CITY OF ALBUQUERQUE

September 10, 2012

**Re: Guardian Storage-Holly Conceptual Grading and Drainage Plan,
Engineer's Stamp Date-no stamp- (C19/D056)**

CONCEPTUAL GRADING AND DRAINAGE PLAN GUARDIAN SELF STORAGE

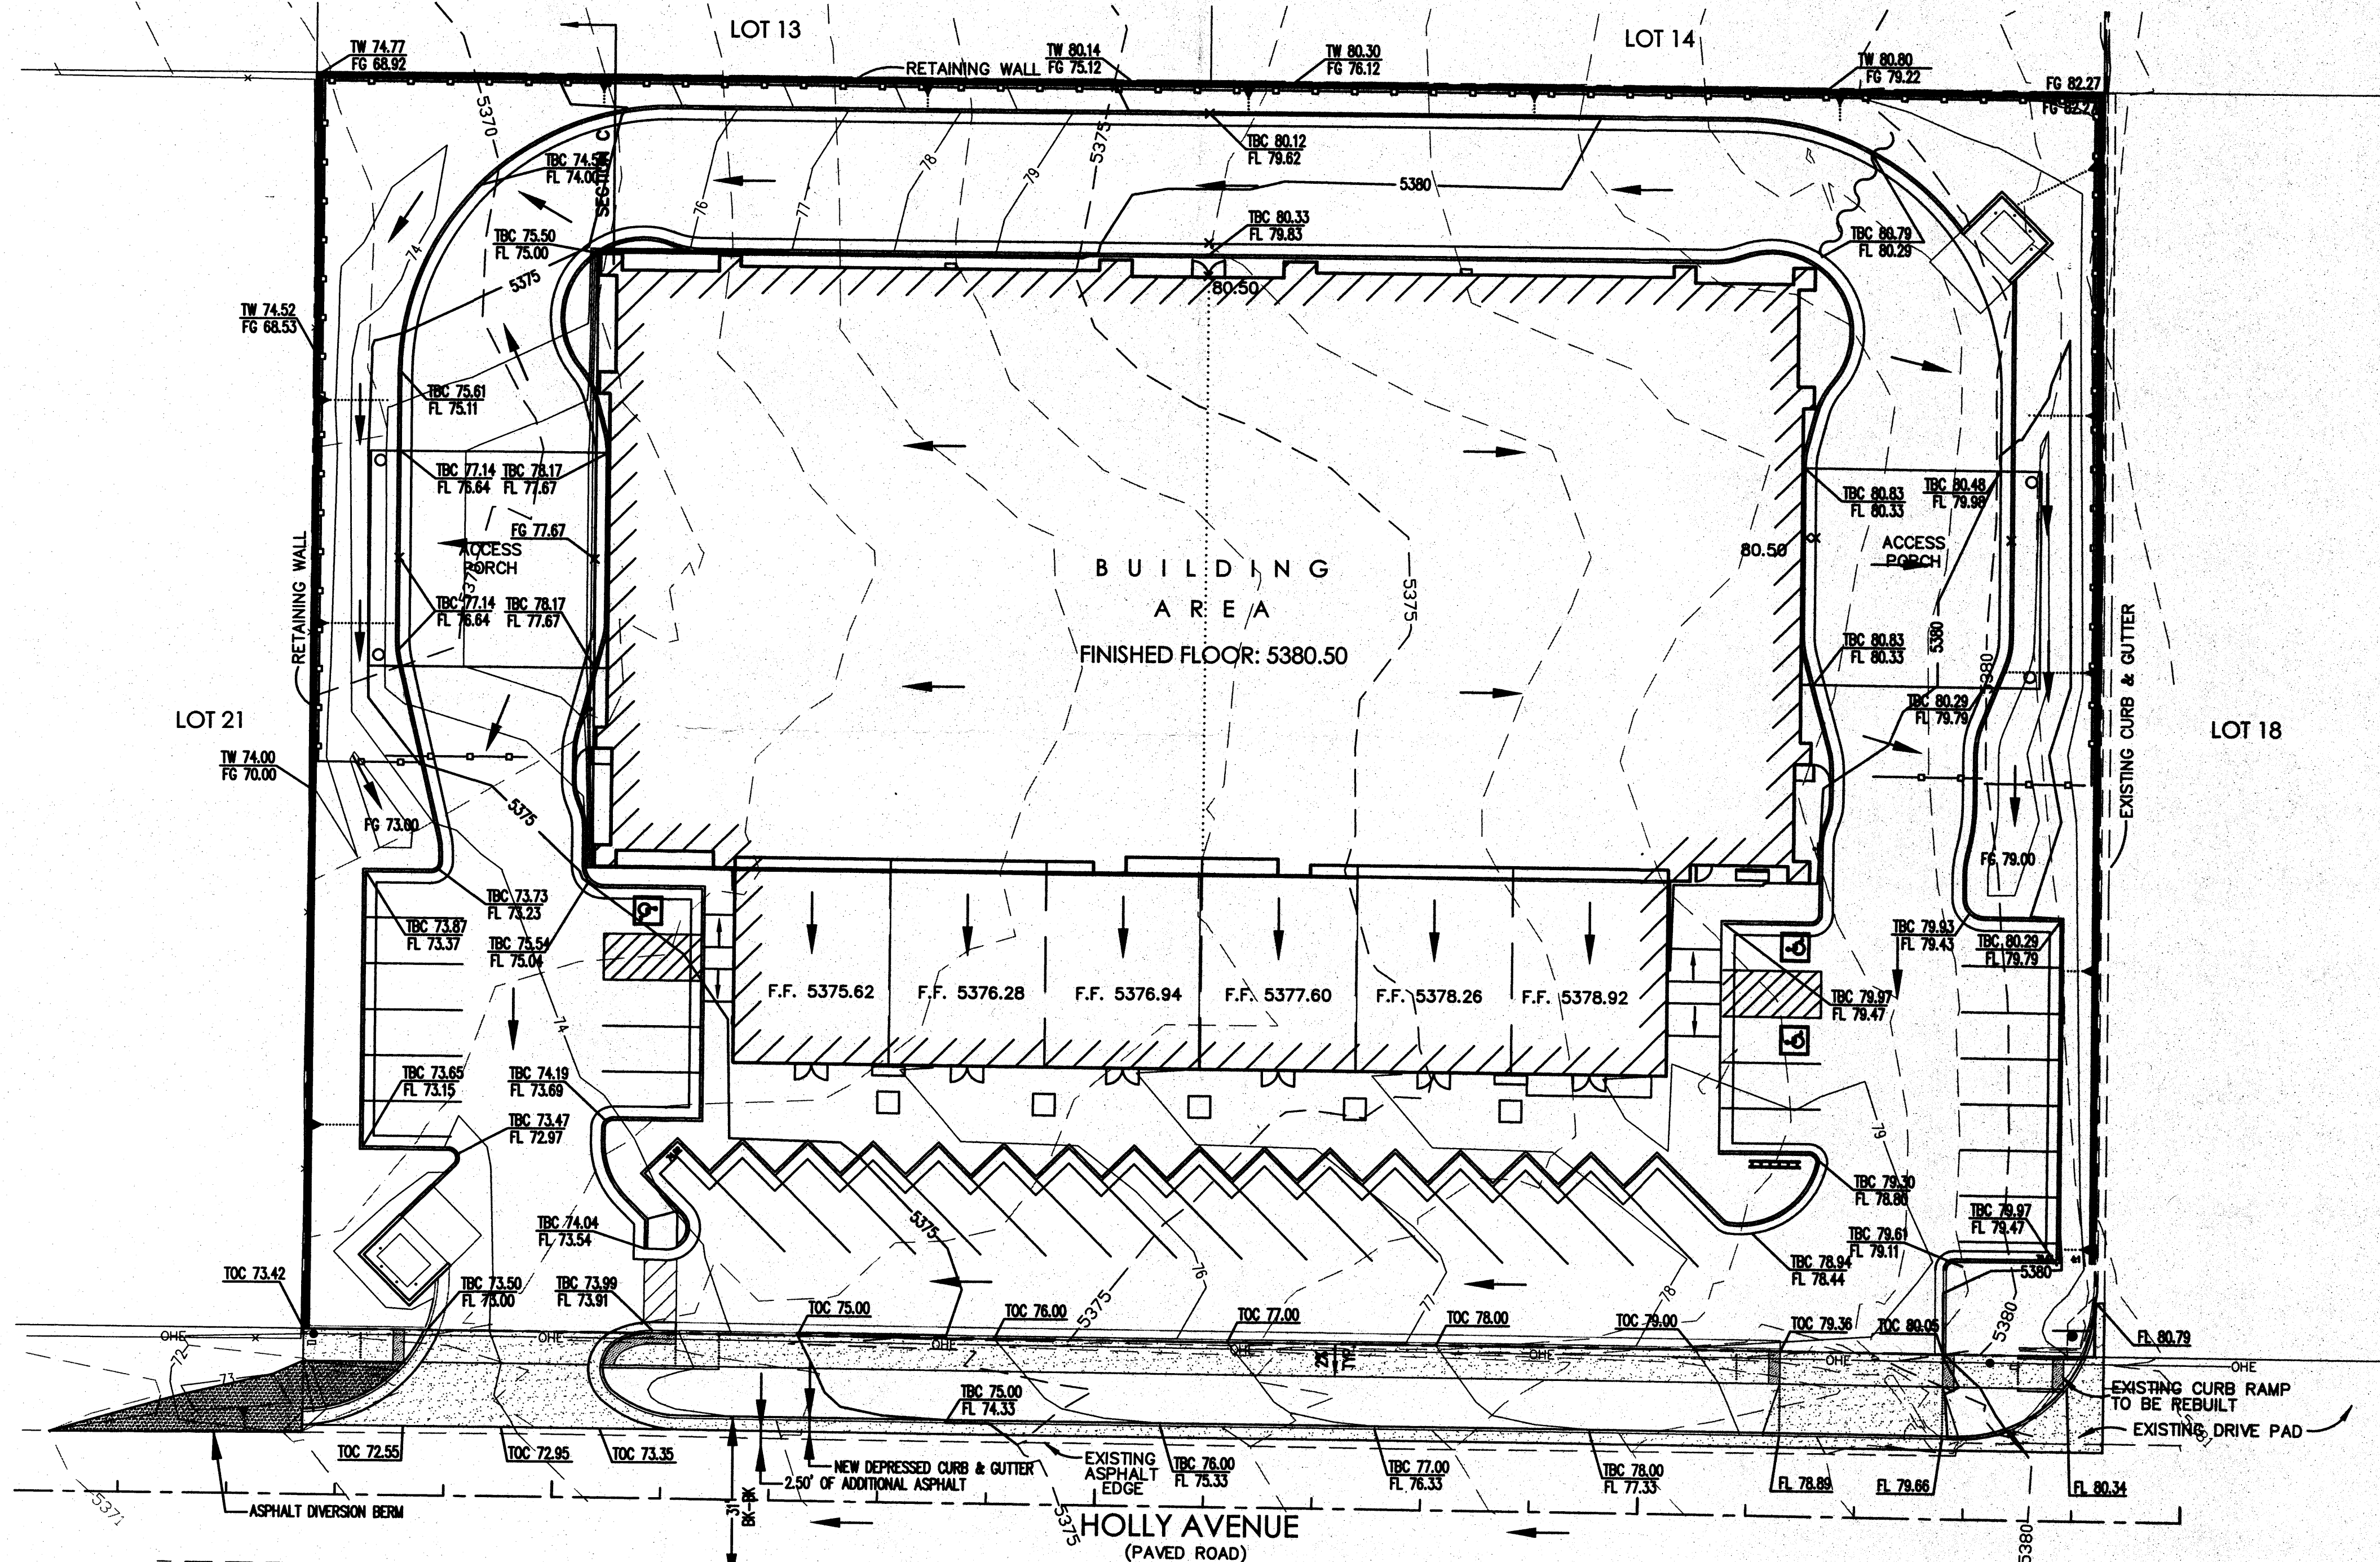
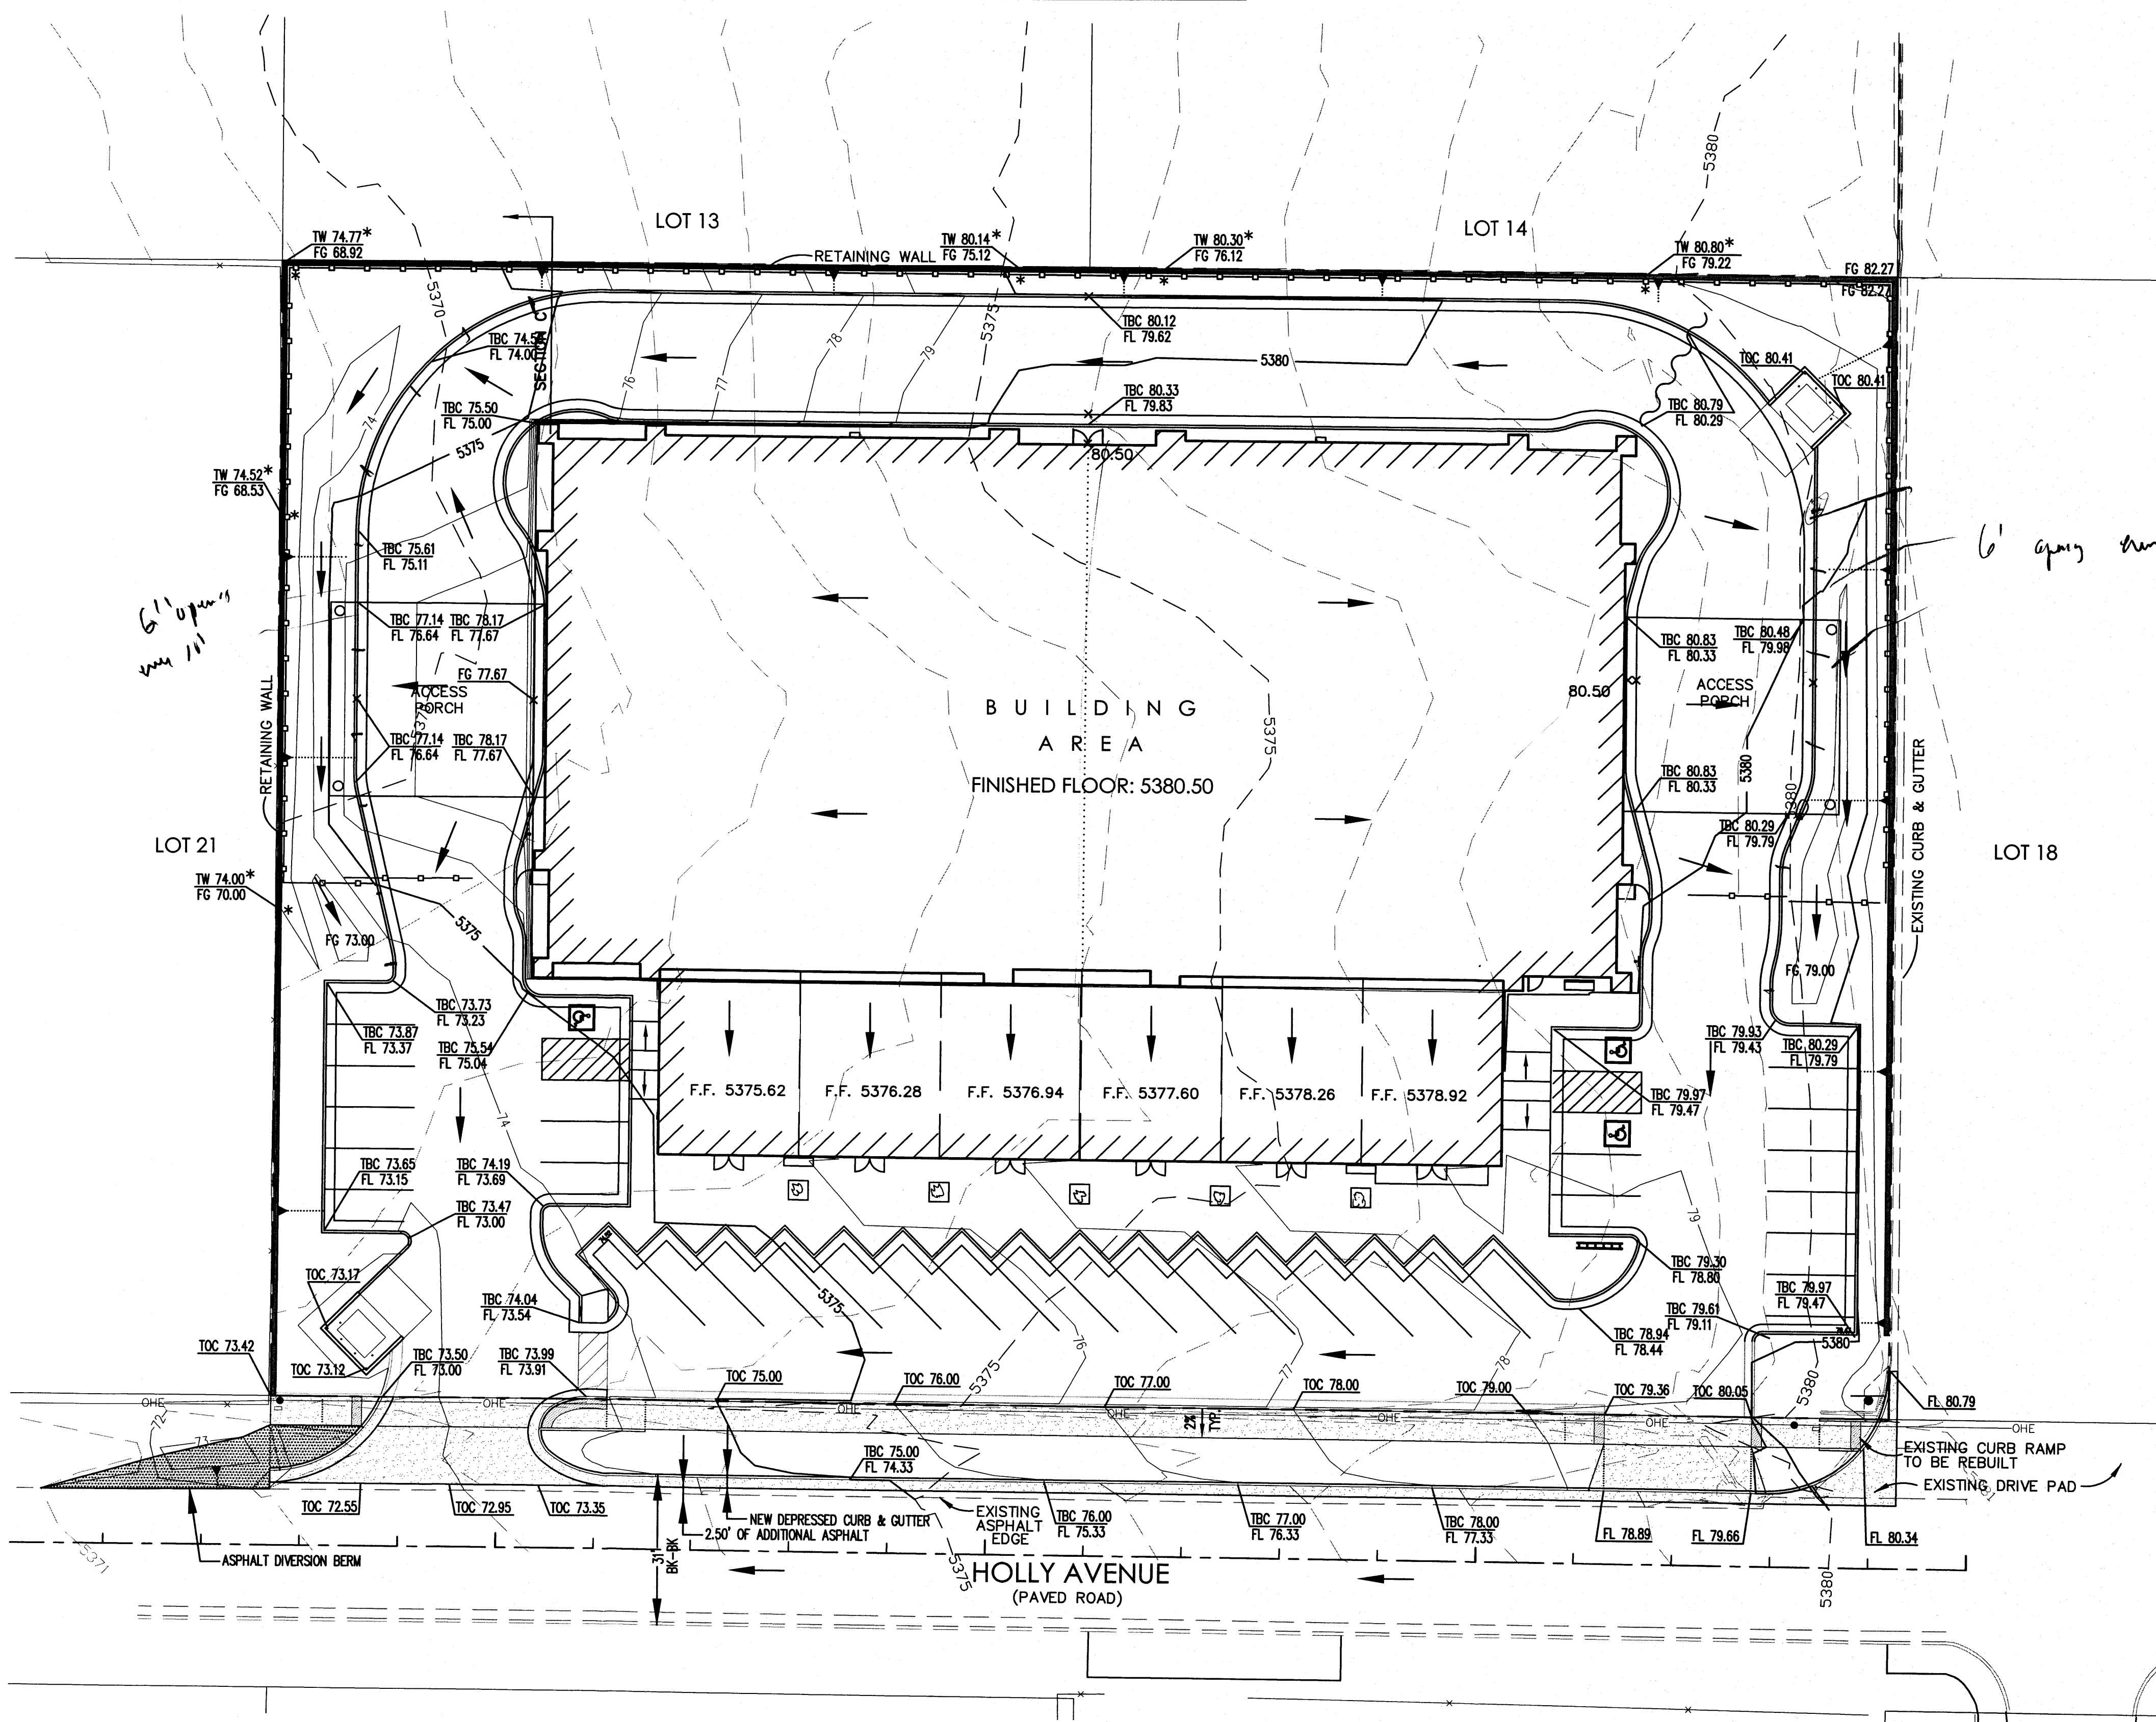
- Show existing contours on the lot to the west.
- Provide flow line elevations on Holly Avenue.
- Additional elevations should be given on sidewalks.
- Standard flow and volume calculations per the DPM will be required.
- Provide a vicinity map.
- This review was performed for conceptual purposes only. Additional comments may be provided when submitting for Building Permit approval.
